Application No: EP/21/22/HH  
Site Address: 35 The Ridings East Preston BN16 2TW  
Description of works: Installation of front dormer.

Thank you for your internet representation made on 29th March 2022 which has been recorded as an objection with the comments as follows:

This council's Planning & Licensing Committee considered this Application at its meeting on 14th March.

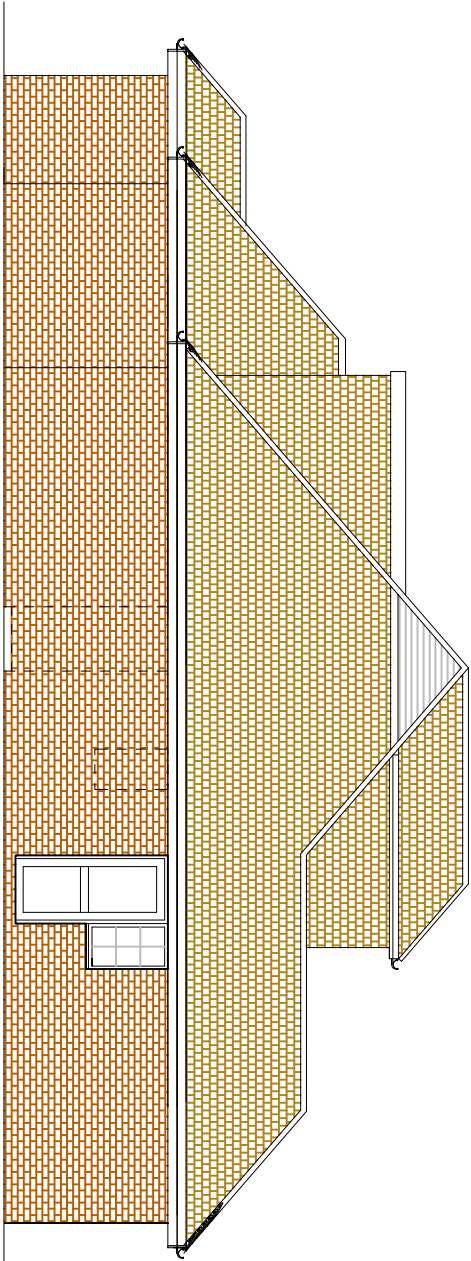
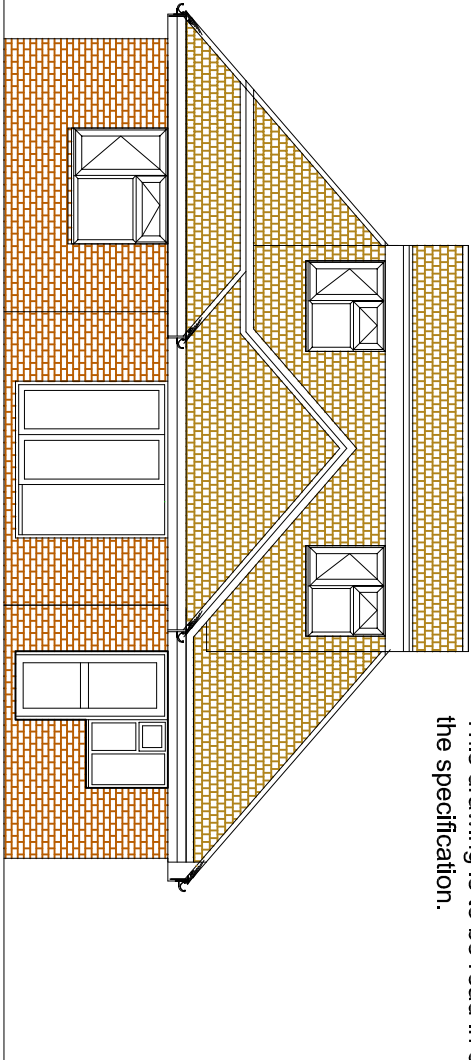
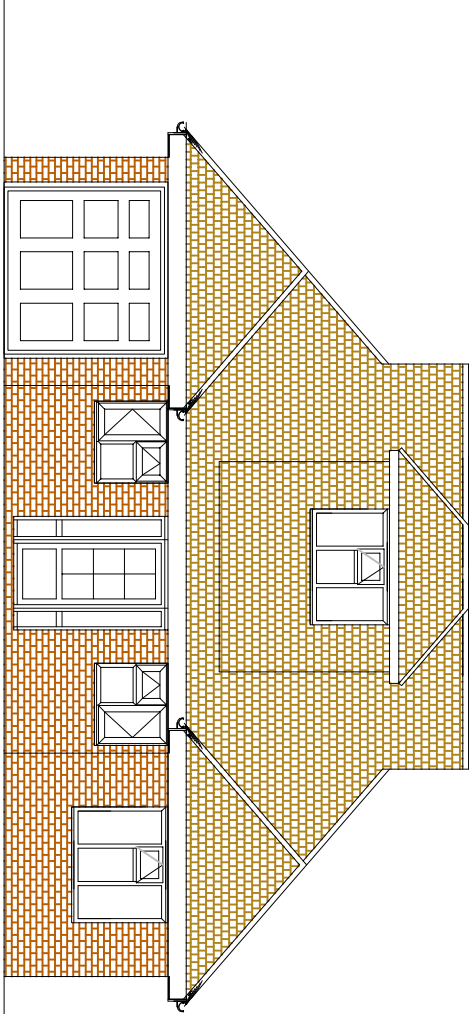
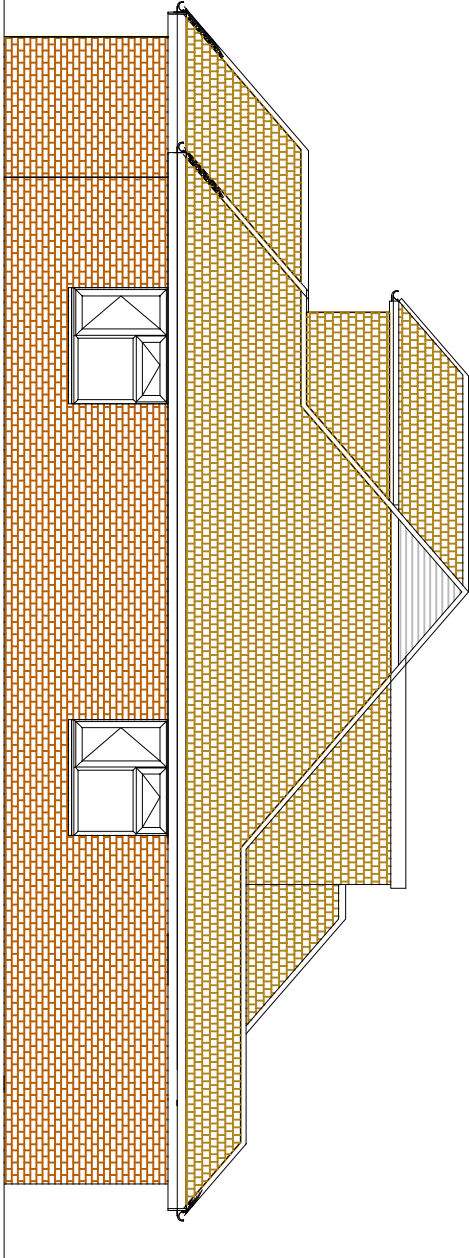
The committee AGREED unanimously to object to this Application on the grounds the property is currently one of an attractive pair of bungalows and this would unbalance the pair. The committee felt the proposed alterations were perhaps heavy-handed and could result in a rather less attractive building than it is currently. The rectangular redesign of the roof could have a particularly negative impact upon the streetscene of a road in which most properties have retained their 1930s essence.
